My Ref: 601/ROM/PK
Your Ref: H13-1081-22

**TOWN AND COUNTRY PLANNING ACT 1990
PLANNING CONSULTATION**

Residential Development, Rear of 18 Roman Bank, Moulton Seas End, Spalding PE12 6LG

Project	RESIDENTIAL DEVELOPMENT EAST OF I-18 & 200 BOWMAN PARK, MOLITION 35.45 BLD. SPALDING, LINC 5, FBI 2 BLD.		
Client	J. HITCHAM.		
Drawing	SITE & LOCATION PLANS.		
Job Ref.	4087-22.	Drawing No.	01.
Date	OCTOBER 2022.	Drawn	S.L.D.

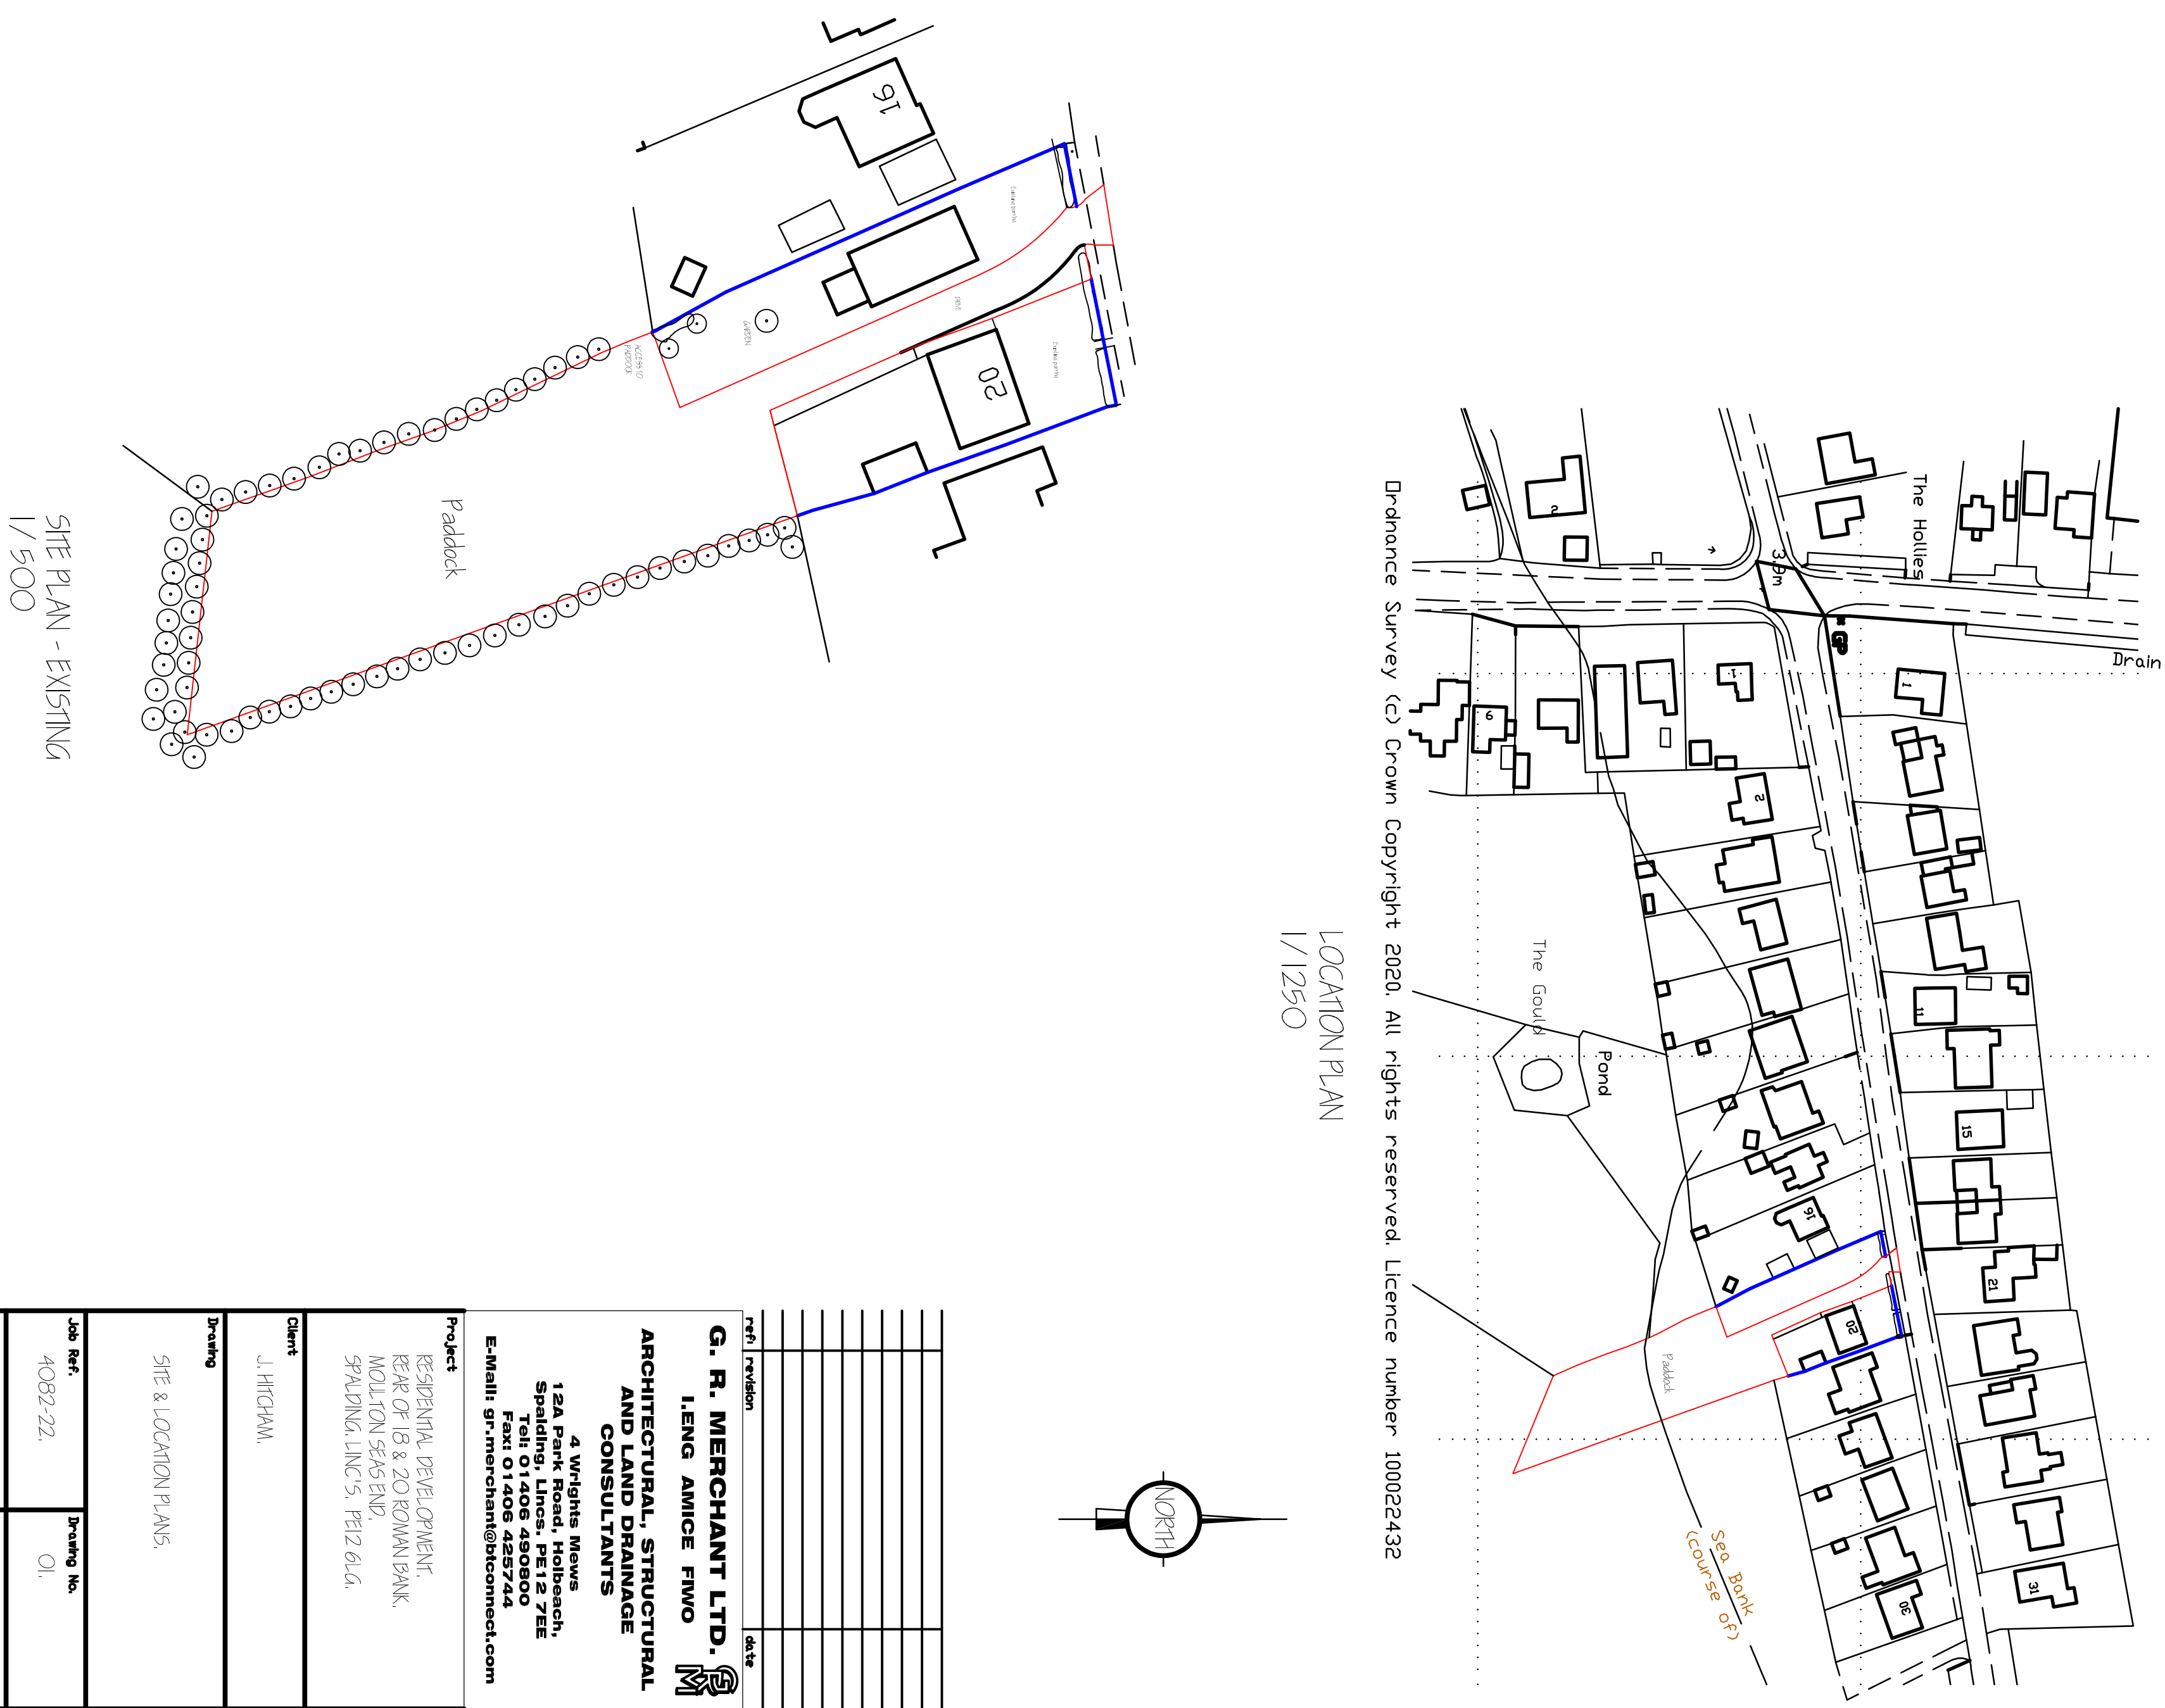
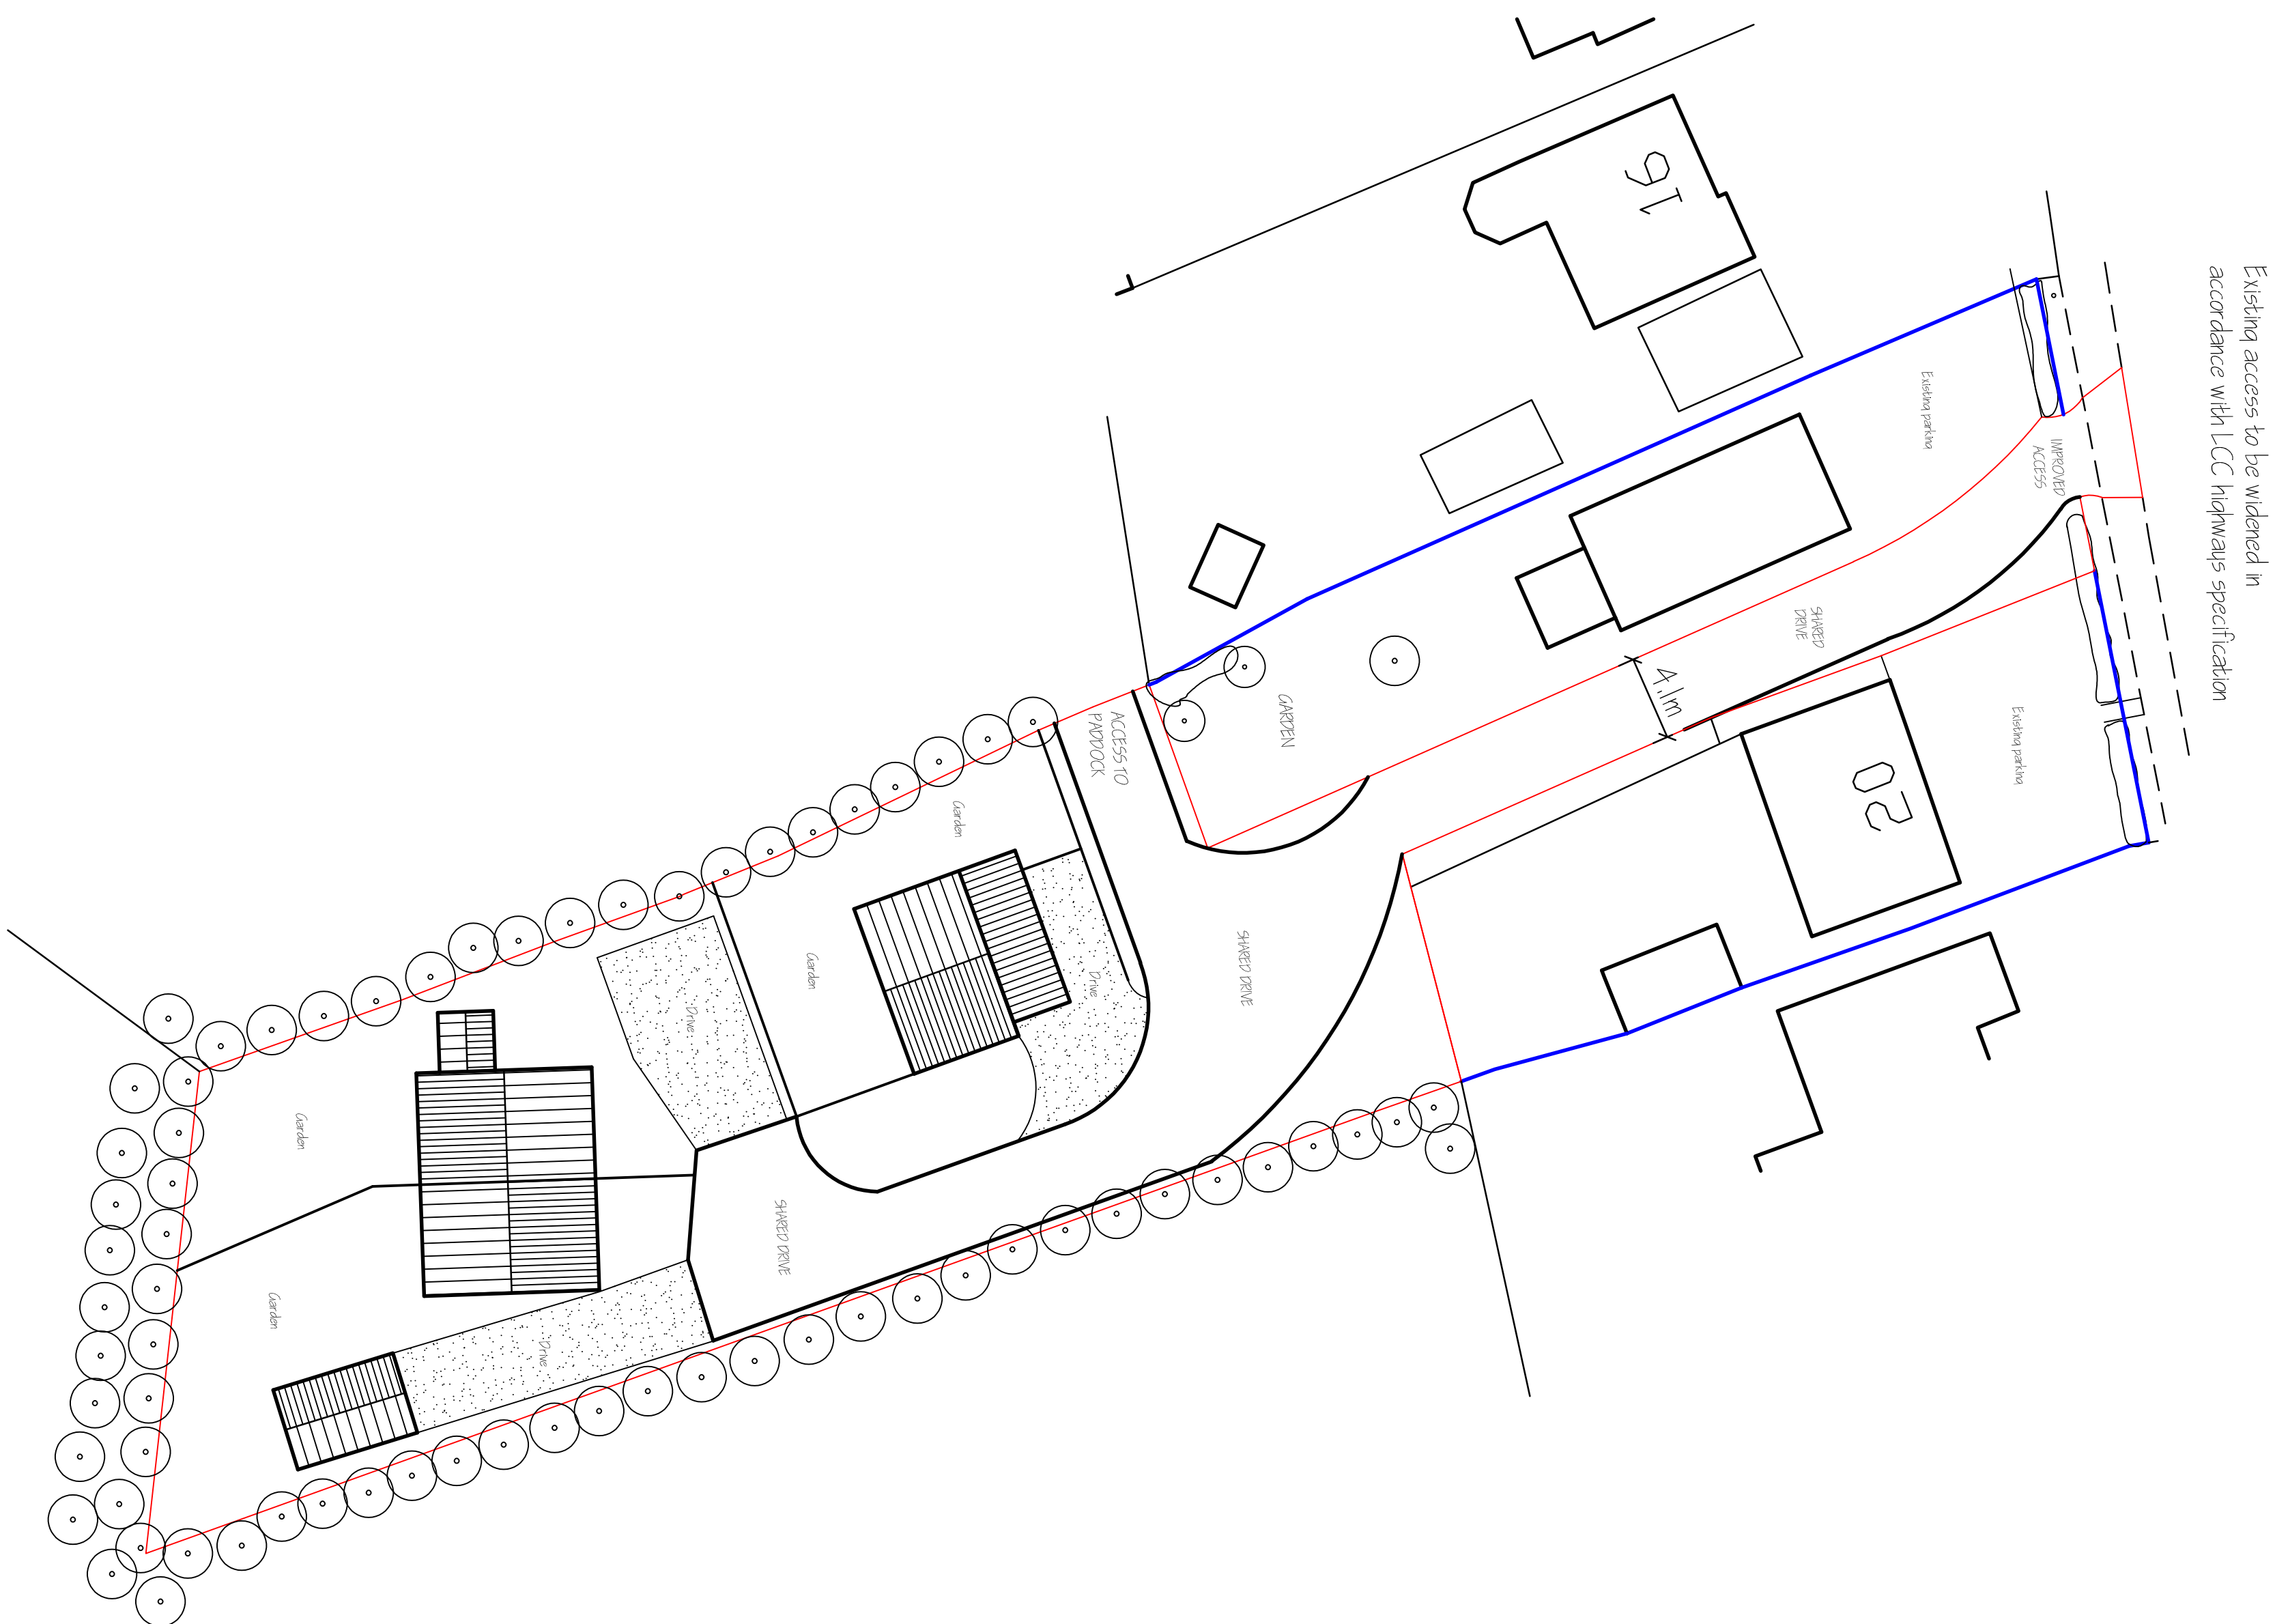
I refer to the submitted planning application reference H13-1081-22. The Fire Authority objects to this planning application on the grounds of inadequate access and turning for a fire appliance. This is the opinion of the Fire Authority as a specific requirement under the Building Regulations.

Access to buildings for fire appliances and fire fighters are specified in the Building Regulations 2010 Part B5. The vehicle access road will be a minimum width between kerbs for pumps of 3.7m. The minimum turning circle between kerbs for pumps should be 16.8m and between walls 19.2m.

A turning facility is required because the dead-end access route is over 20m long. This can be a hammerhead or a turning circle.

Lincolnshire Fire and Rescue also requires that the access road surface construction is of minimum carrying capacity for pumping appliances of 18 tonnes and not 12.5 tonnes as detailed in the Building Regulations 2010 part B5.
